Re: 120-128 Herring Road, Macquarie Park MP09_0217

After review of the Project Approval conditions and the associated documentation we have found a minor dimensional inconsistency upon the Stage 2 Subdivision Plan.

The new plan set for each Stage have been annexed to this letter, both Sets are now known as Revision 8 with a print date of 8TH March 2011

BOUNDARY & EASEMENT LOCATION FOR GROUND LEVEL & ABOVE

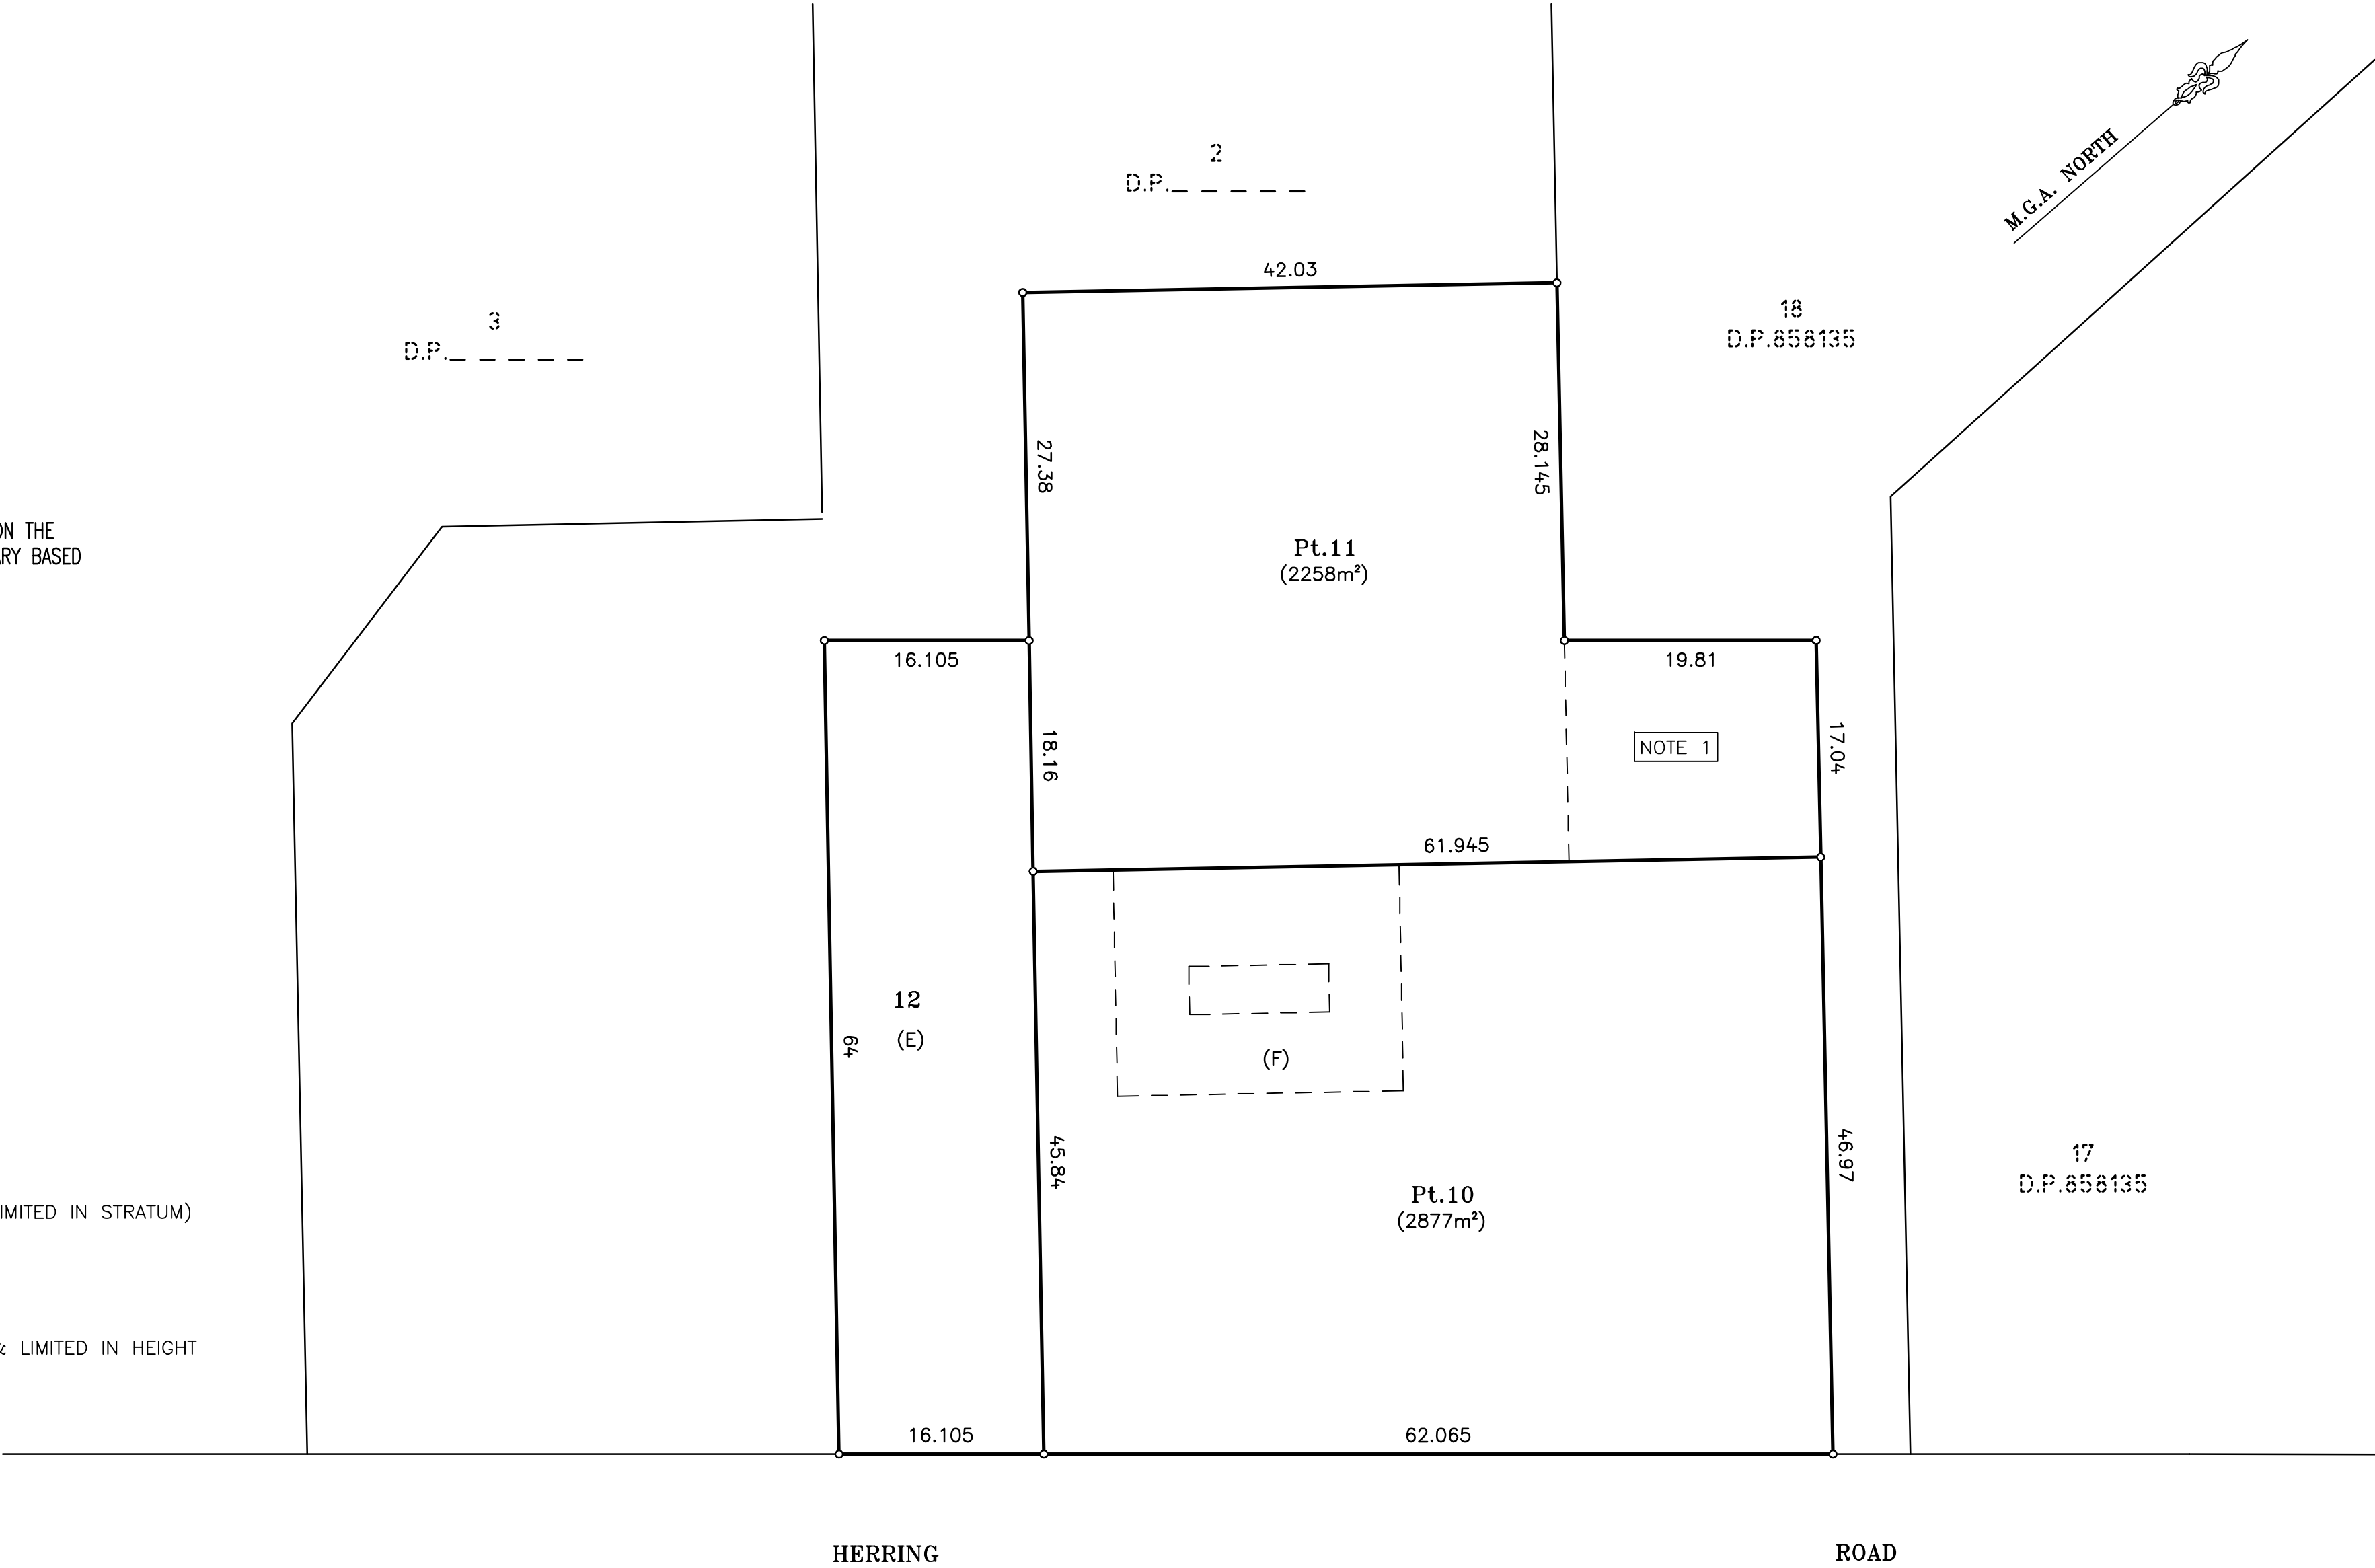
As requested by Lipman we have also modified the wording to the pedestrian and Cyleway easement upon the Stage 1A plan. This easement was previously referred to as a "Right of Footway Variable Width (X)". The easement is now to be known as an "Easement for Access (Pedestrian & Bicycle) 2.5 wide (X)"

Surveyor: CAMERON PHILLIP MILES Date of Survey: 05/01/2010 Surveyor's Ref: 091120.DP.STG2	PLAN OF SUBDIVISION OF LOT 2 IN D.P. _____ STAGE 2	LGA: RYDE Locality: MACQUARIE PARK Subdivision No: Lengths are in metres. Reduction Ratio 1: 750	REGISTERED	DP
---	---	---	------------	----

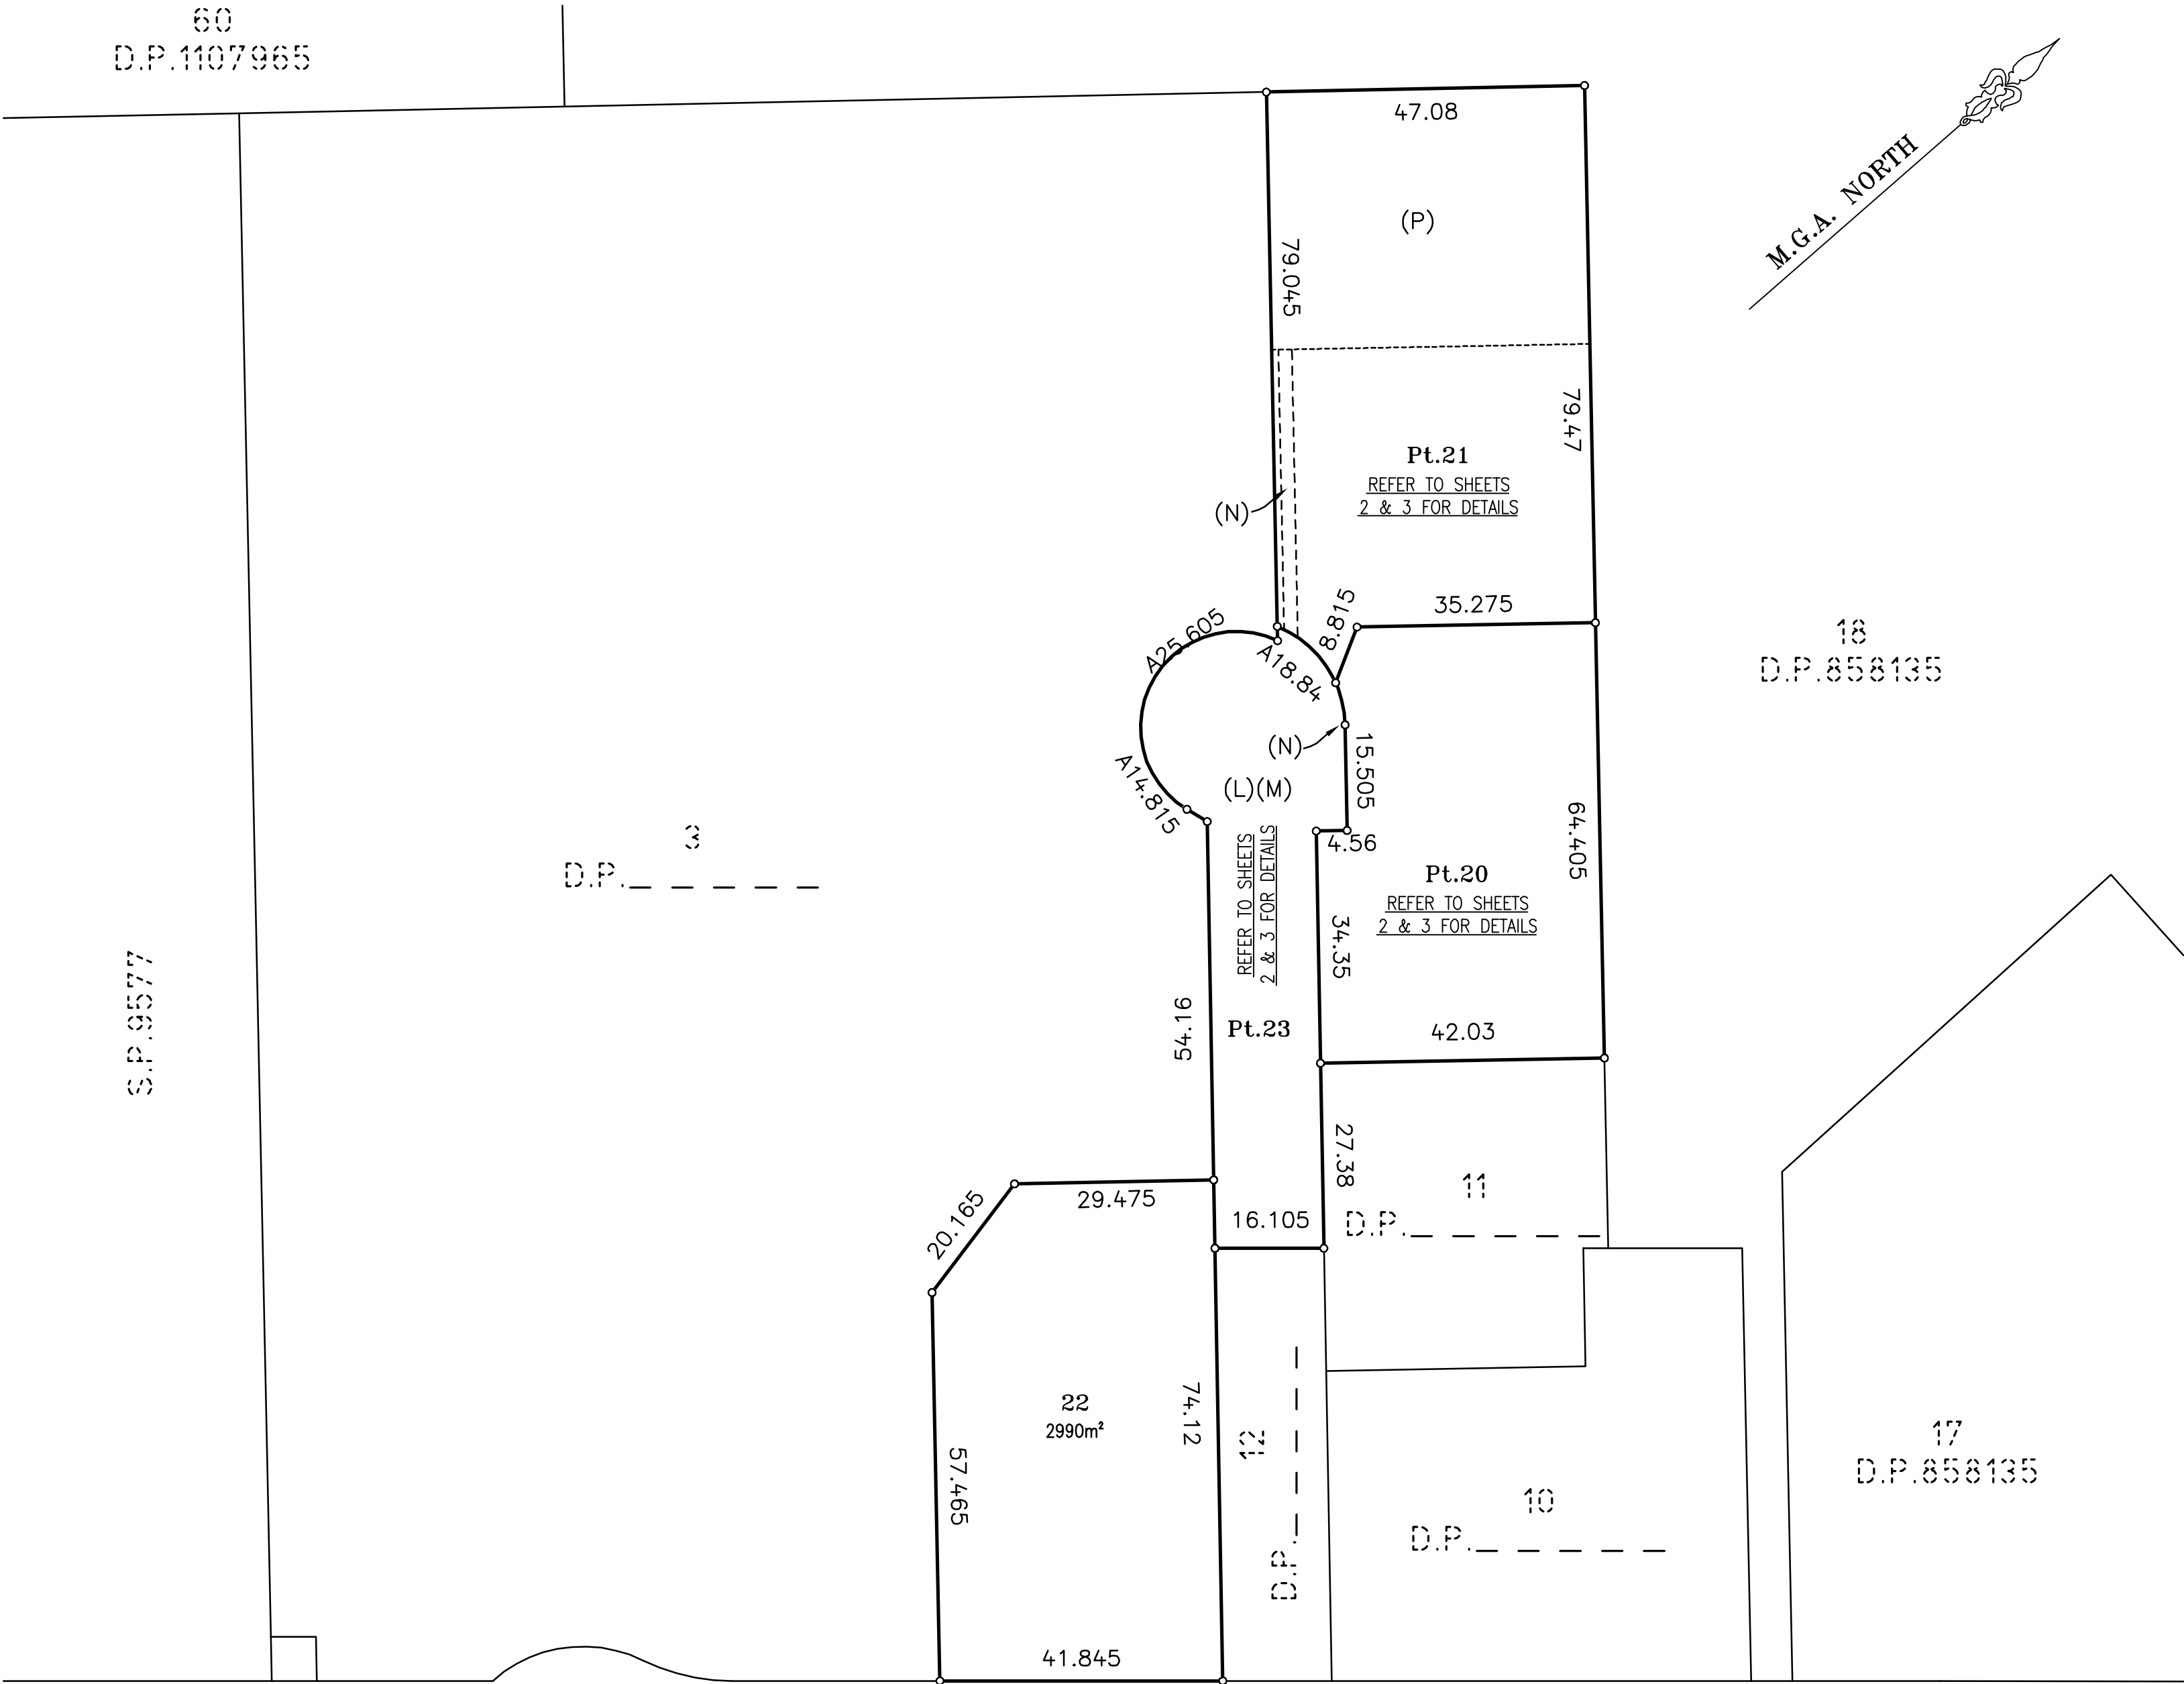
This inconsistency is upon Sheet 1 of the Stage 2 Plan, with the dimensions around the Cul-de-Sac head. The correct dimension, as previously shown on Sheet 3 remain unchanged . The areas of the associated parcels remain unchanged.
